Online Comment

Application H13-0292-25
Location Holly Tree House Fengate Moulton Chapel PE12 0XR
Proposal Proposed replacement dwelling

Name Greg Watkinson
Address Conservation Officer

**Elevations as proposed**

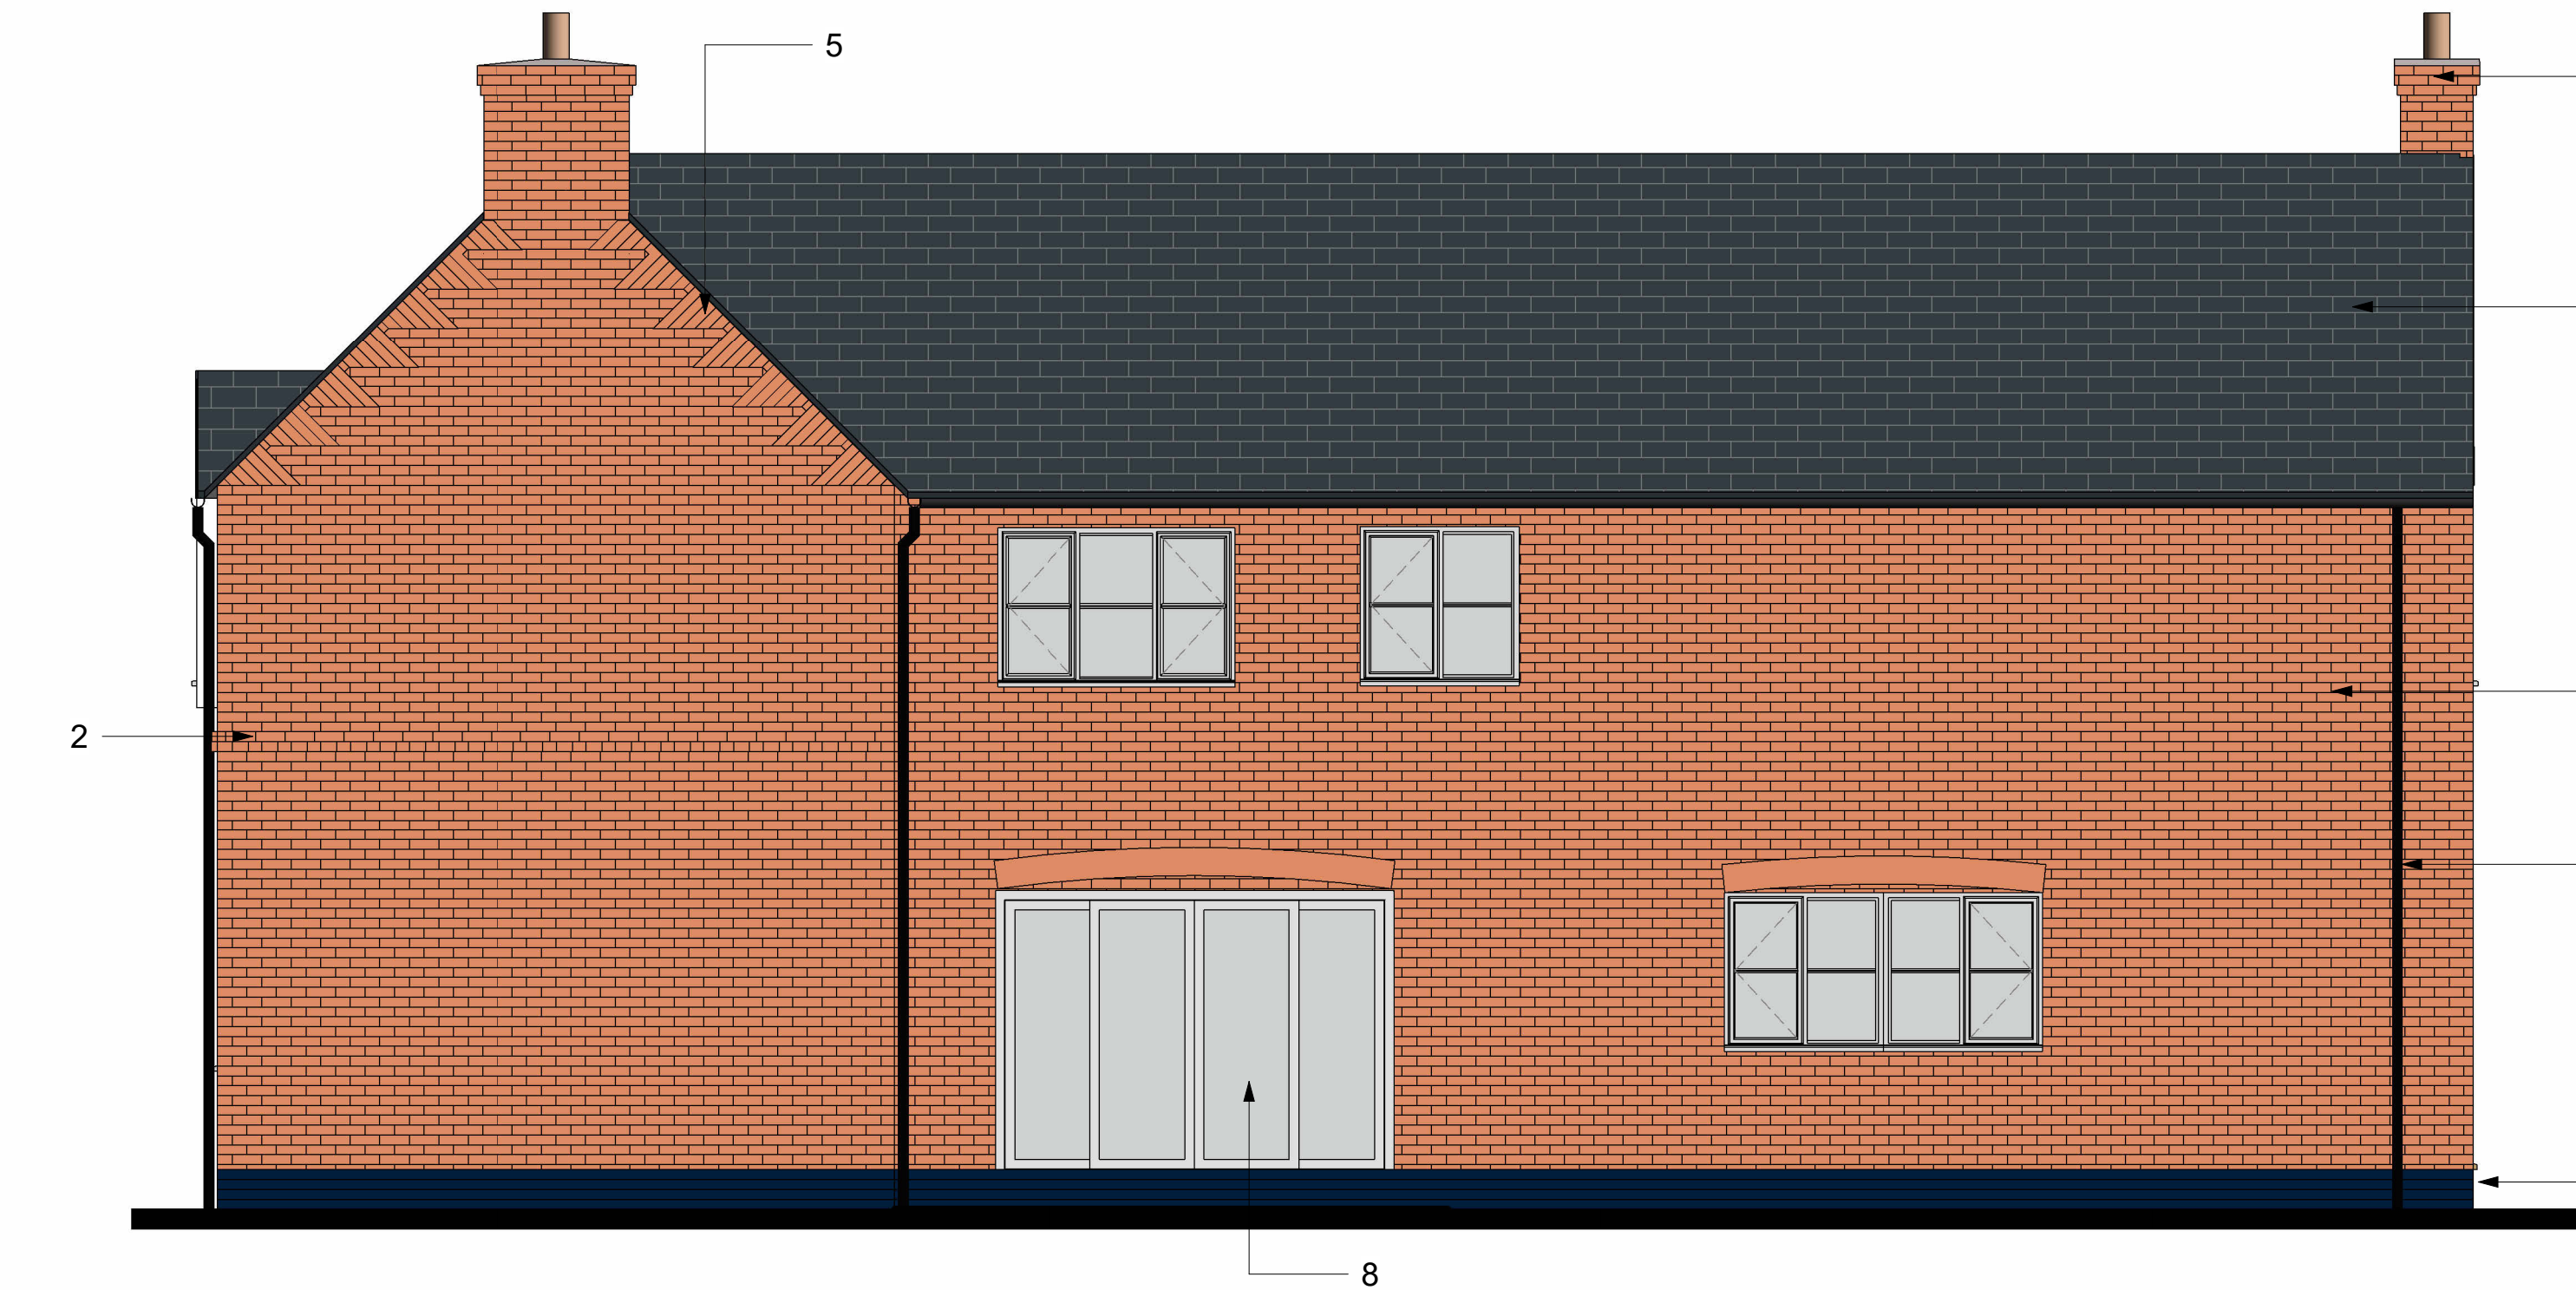
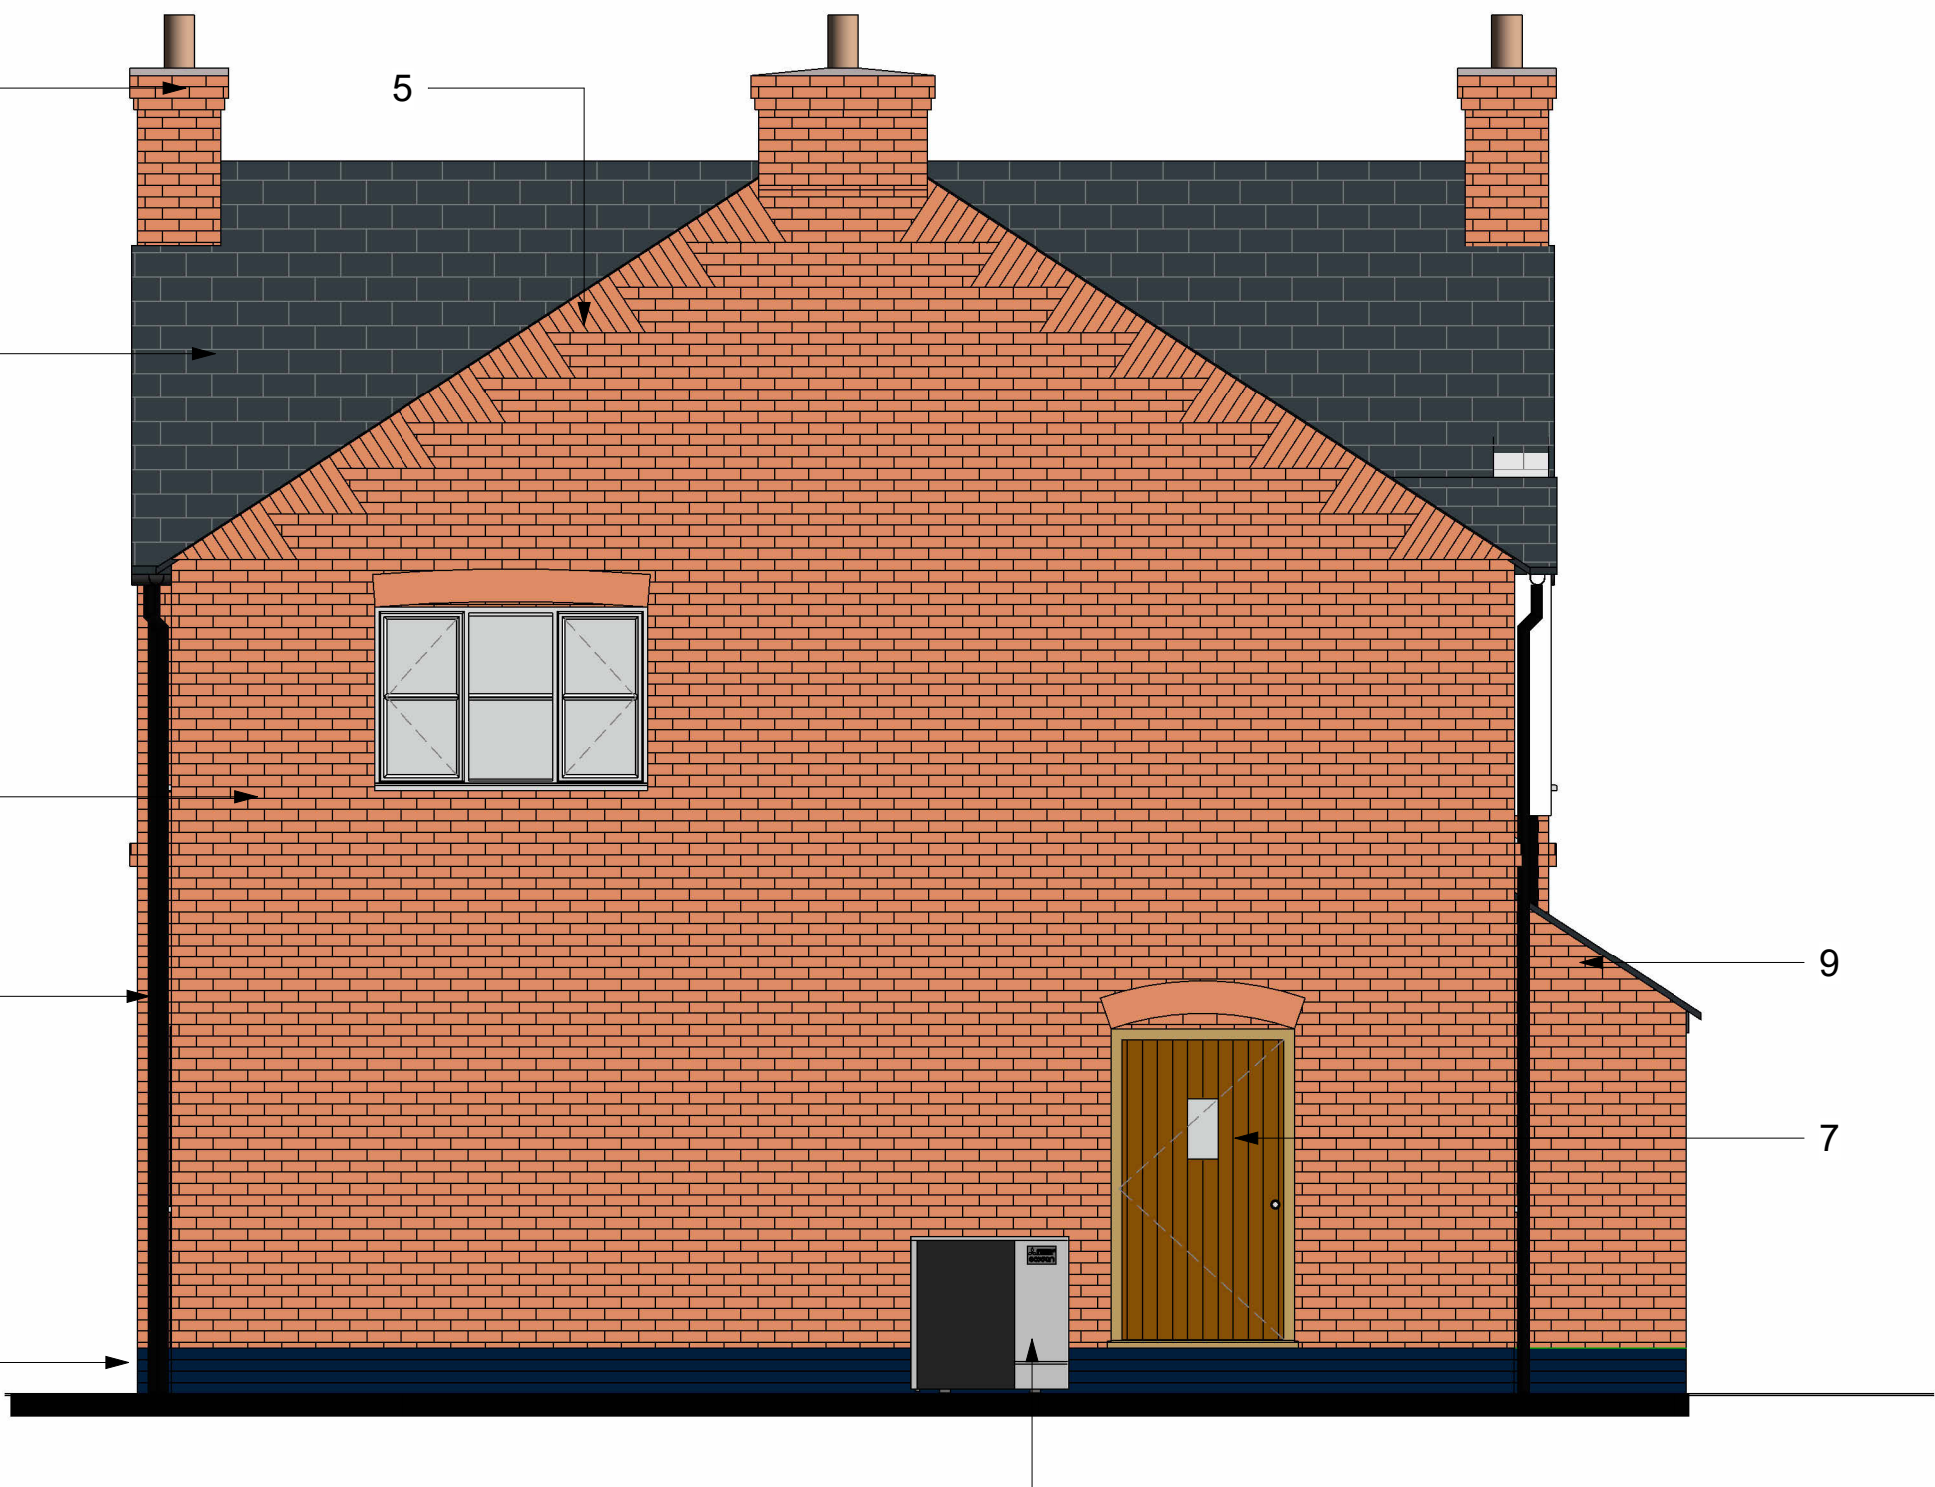
Moreover, this building retains some architectural value. Whilst it is clear it has been heavily altered over time, including with some harsh and non-sympathetic alterations, particularly in the form of cementitious coatings and various crude UPVC additions, the basic form and pattern of the building is one of a fairly traditional rural farmhouse with some interesting detail and significant potential for aesthetic improvement. Based upon P22 of the SELLP, I would therefore suggest that the extant property is of some architectural value, and it has not yet been shown that the structure is not capable of repair. Moreover, I am not satisfied that the proposed design is of a high enough quality to justify the loss of the extant structure. It is appreciated that the architect has gone to some lengths to replicate the traditional visage of the southern elevation, referencing the design of the extant. However, the remaining aspects of the other wing of the proposed structure appear relatively unsatisfying, giving the appearance of a relatively standard, somewhat slab-sided modern newbuild property.

I would suggest, given that this site is within the immediate context of a recognised heritage asset, the design should have to be much more sympathetic and in some senses outstanding in order to justify itself.

In summary, I cannot support the application as proposed. I would expect that the applicant should be required to satisfactorily justify the reasoning behind why the original structure cannot be retained, and should the applicant be able to provide such satisfactory justification, the design should be reconsidered, particularly to ensure that the north-pointing 'wing' of the building is better treated to avoid appearing overbearing and featureless, particularly when viewed from the roadside and in the context of the adjacent heritage asset.
